MODIFICATION REQUEST:
Residential Subdivision
Dolphin Point Road and Wuru Road,
Dolphin Point
05_0016 MOD 2 (Concept Plan & Project
Application)

Secretary's
Environmental Assessment Report
Section 75W of the
Environmental Planning and Assessment Act 1979

May 2014

INDICATIVE LOT LAYOUT FOR PRECINCT B SUBDIVISION
DOLPHIN POINT CITY OF SHOALHAVEN

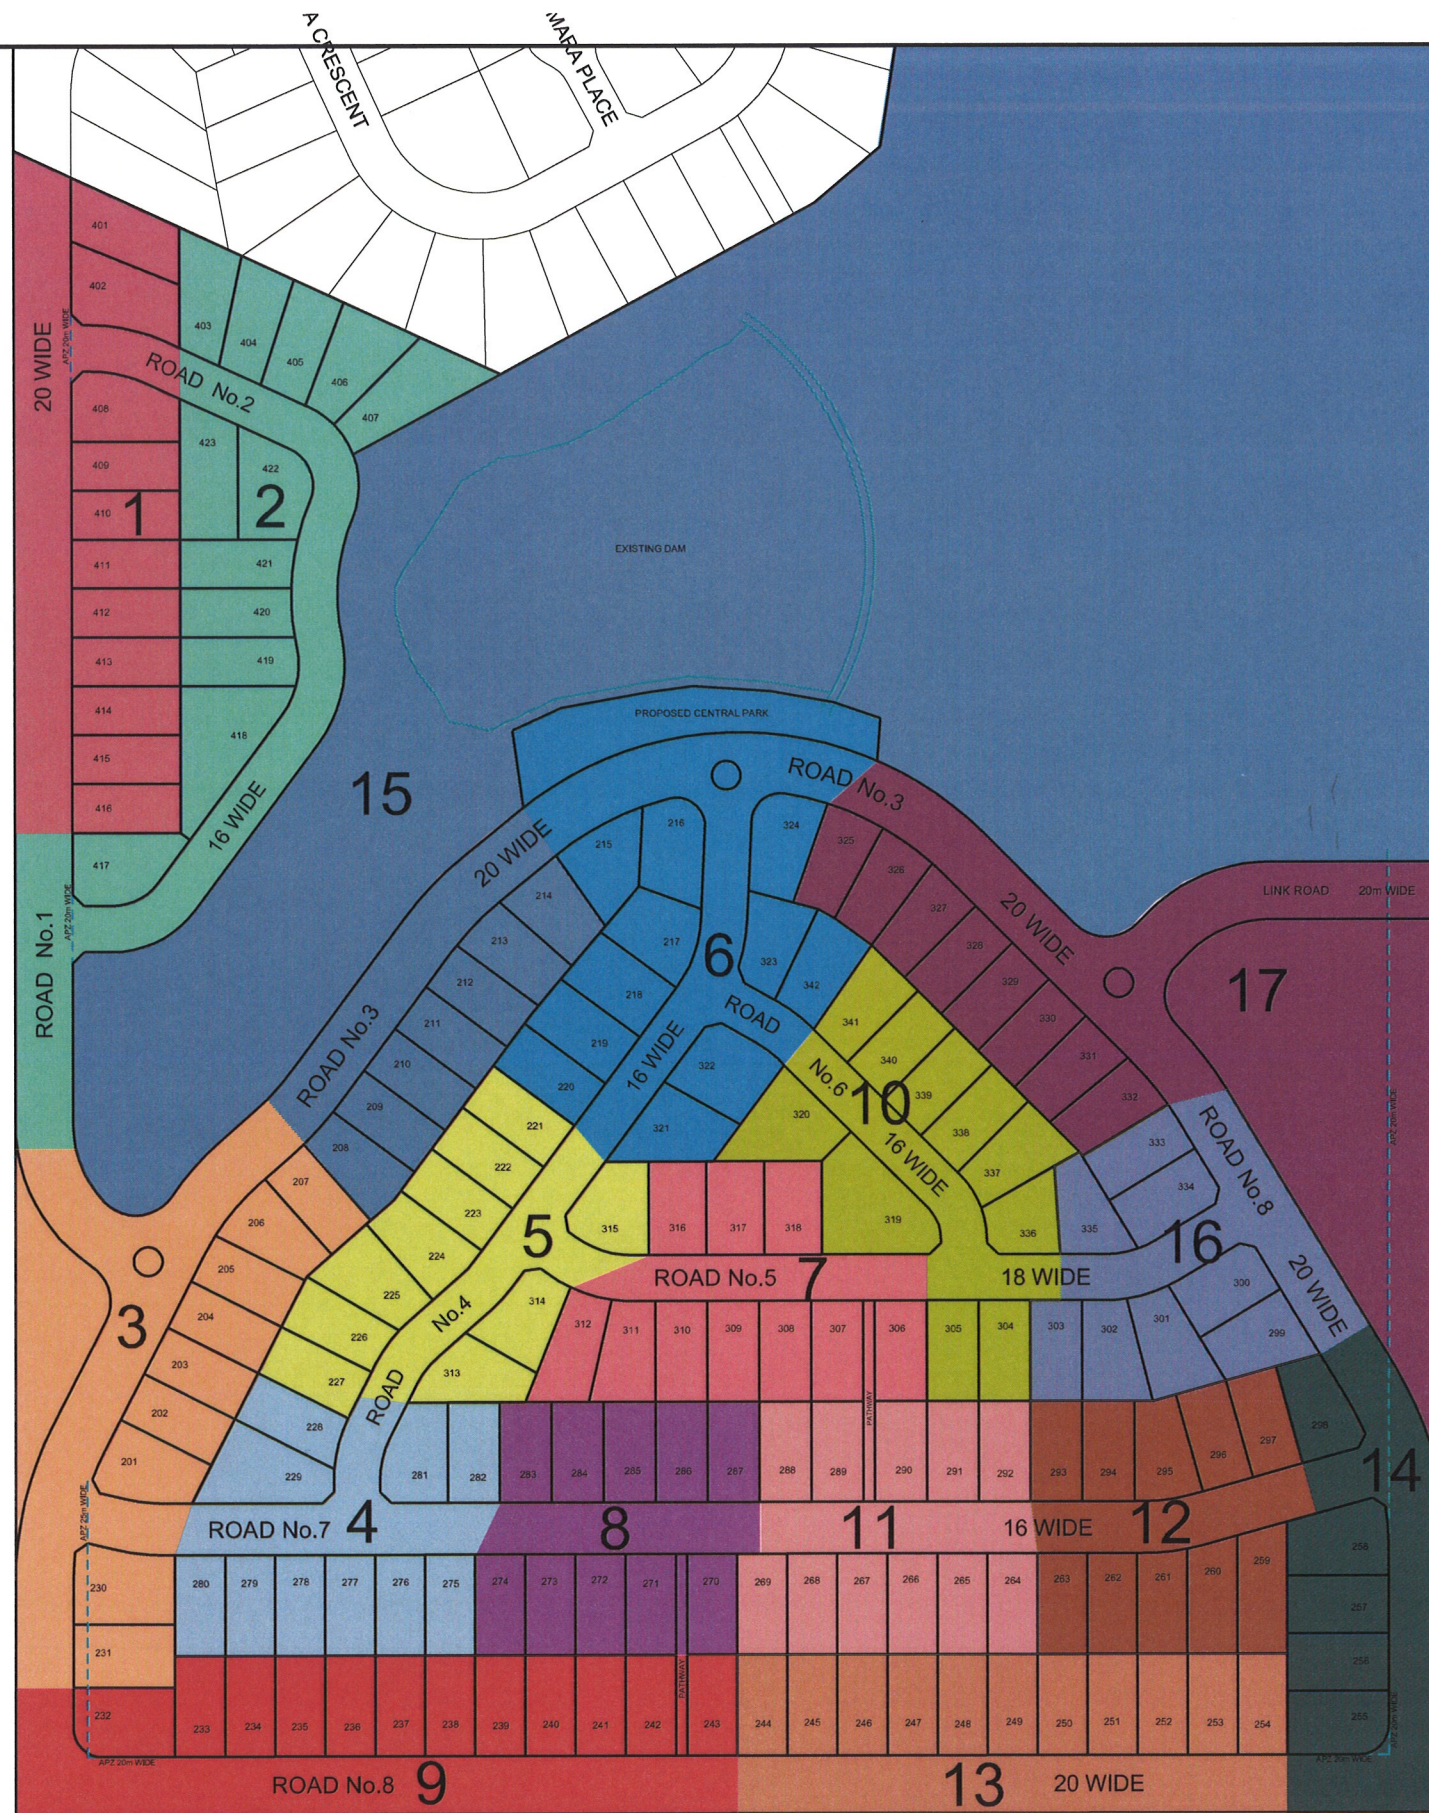
- **Condition B20** - Council supports the aggregation of the open space as generally proposed, however, has some concerns with respect to the area, reference to a

- that the park is provided after 60 lots are created and not after 147 lots are created as per the Proponent's request;
- that the embellishments required by the original condition are provided, with no requirement for toilets. The Narrawallee references should be removed;
- BBQs should be electric and to Council's standards; and
- the aggregated area of the consolidated park should be 1500m² and not the 1000m² currently proposed by the Proponent.

The Proponent proposes to consolidate the proposed neighbourhood park proposed for Precinct A (required by Condition E18) and the informal park (required by Conditions B20 and E19) into a larger 'central' park within the central area of the site. Council supports this consolidation as it would result in a greater area of usable public open space in a more central location (refer to **Figure 6**). As a result of this consolidation of the open space into one park, there is an additional lot proposed in Precinct B in the location of the former neighbourhood park. The modified proposal therefore involves 165 lots, instead of 164 lots.

Council considers that Condition E18 can now be deleted as the neighbourhood park is no longer required. The area formally reserved for this small neighbourhood park is now proposed to be a residential lot with an adjacent drainage reserve. The proposed pathway between roads 5 and 7 which originally passed through this proposed park is still proposed between the residential lots in this area. The department considers this to be an acceptable urban design outcome for the site and Council concurs. Conditions B20 and E19 are to be modified accordingly. These changes are illustrated in **Figure 6**.

Council agrees to require the plans for this park prior to the issue of Construction Certificate for Precinct B Stage 3.

The timing for the provision of this central park and the plans outlining its embellishment were the subject of negotiations between Council and the Proponent. These discussions have resulted in agreement that the park will be provided once 60 lots have been created which will be at the completion of the development of Stage 6 Precinct B (following Stage 6, 63 lots will have been created). The plans will be required at Stage 3 Precinct B for Council's approval since the final design levels of the surrounding roads to the park will be known at this time. The embellishments required in this park are to remain as outlined in the original condition, with the exception that the toilet is no longer required and BBQs are to be electric to Council's standards.

PLAN SHOWING CONCEPTUAL STAGING
FOR SUBDIVISION OF PRECINCTS A & B
DOLPHIN POINT CITY OF SHOALHAVEN

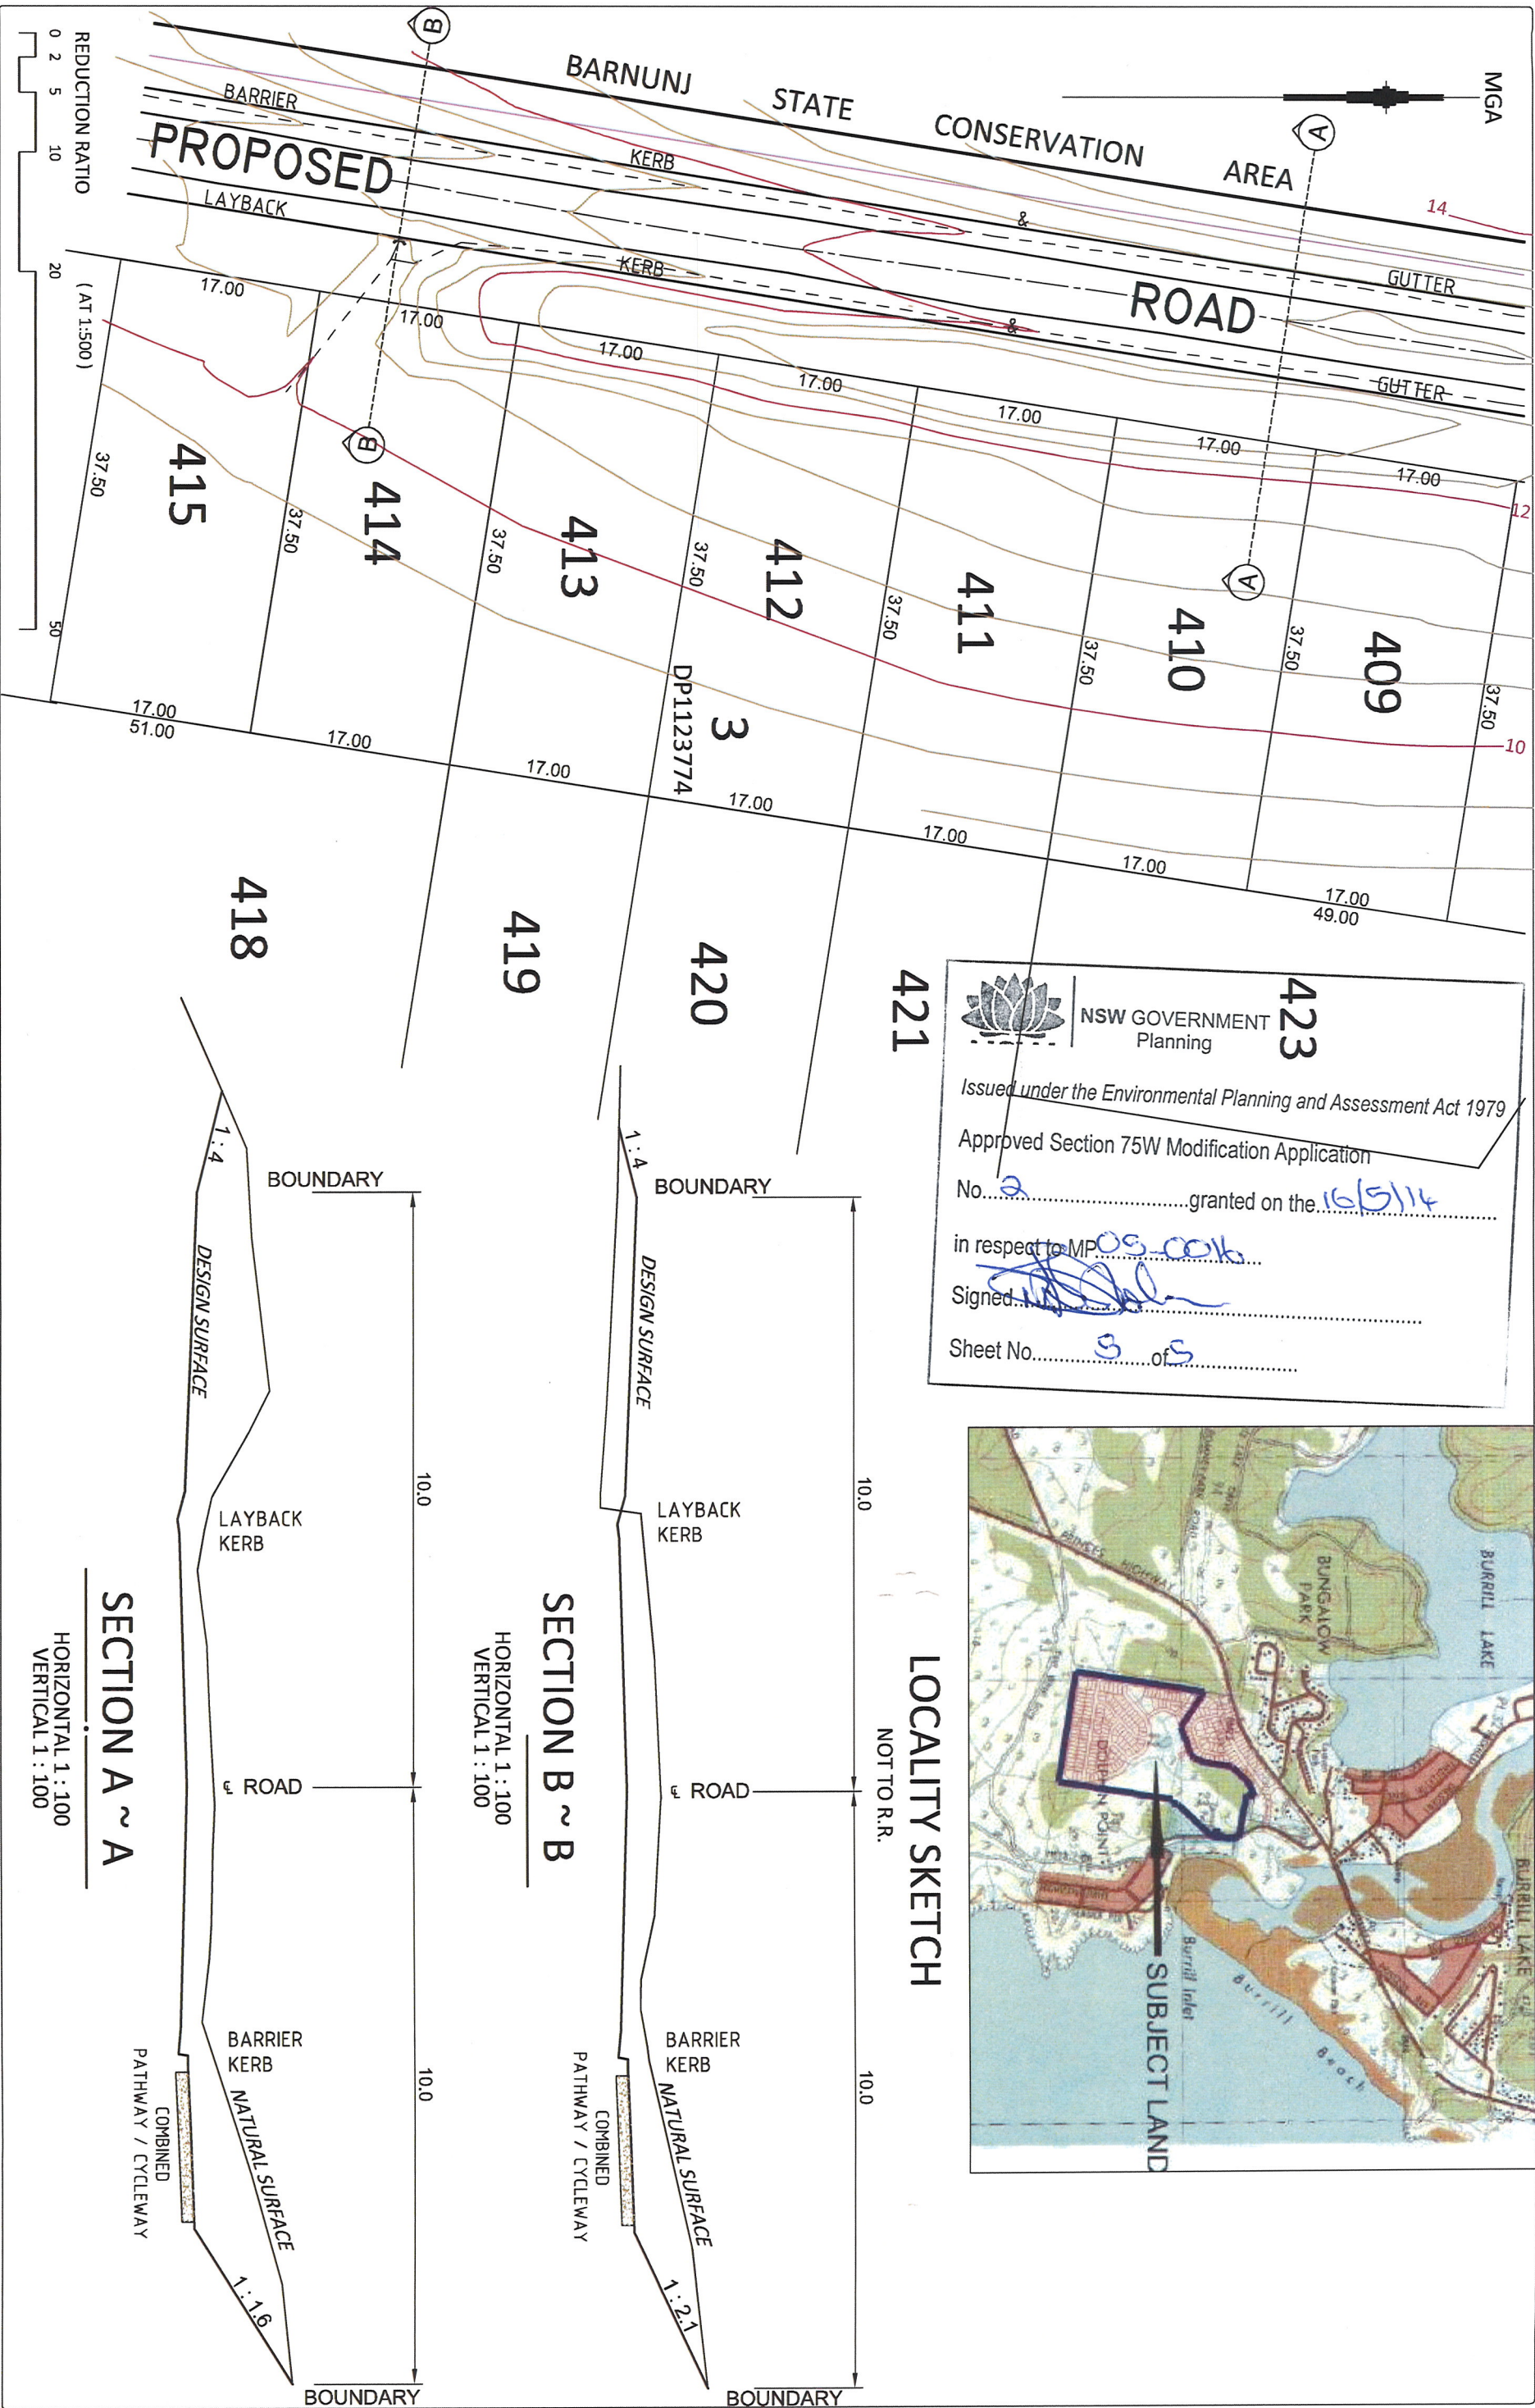
The modifications to the concept and project applications involve changes to the staging of the project, with numerous additional sub-staging within Precincts A, B and C (illustrated in **Figure 4**). This staging is supported as it will provide a logical and clear pattern of lot release on the subject site. The associated changes to conditions in the concept and project approvals with respect to relevant staging, plans and documents are also supported as outlined in **Appendix A, B and F**.

PLAN
SHOWING SECTIONS OVER PROPOSED LOT 410 AND 414
SUBDIVISION LOT 3 D.P. 1123774
BURRILL LAKE
CITY OF SHOALHAVEN

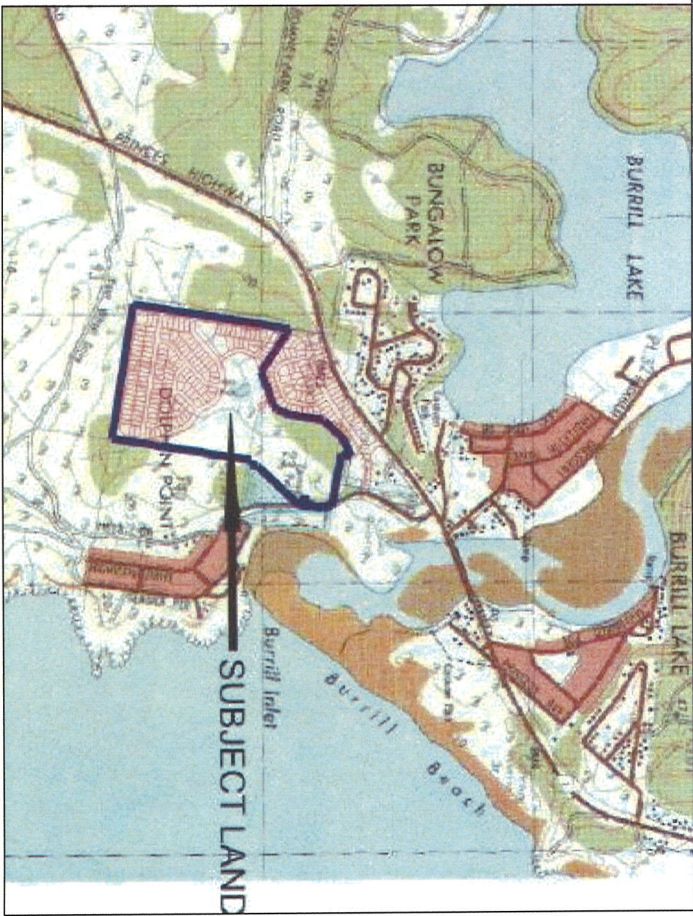
Condition C2 originally required the provision of fencing along the boundary between the subject site and the adjoining Barnunji State Conservation Area. The Proponent requested that this condition be modified to allow for a batter slope with bollards along this boundary to

reduce the costs of this boundary fencing which would be incurred for both construction (by the Proponent) and on-going maintenance (by the Council).

- **Condition C2** - Council does not object to the proposed batter slope with bollards spaced at 1.5 metres as a boundary treatment to the adjoining State Conservation Area.
- **Condition E18** – Council has no objection to the deletion of this condition as the small park area is proposed to be redesigned as a residential lot and an adjacent drainage reserve given the consolidation of the 2 parks into the central park.
- **Condition E19** – Council objects to the timing of the provision of this park. The park should be provided prior the release of the Subdivision Certificate for when 60 lots are created.

Subject to the bollards being spaced at a minimum of 1.5 metres, the Council considered this alternative boundary treatment to be satisfactory to prevent vehicle access to the adjoining State Conservation Area (illustrated in **Figure 7**). The relevant modifications to this condition are supported.
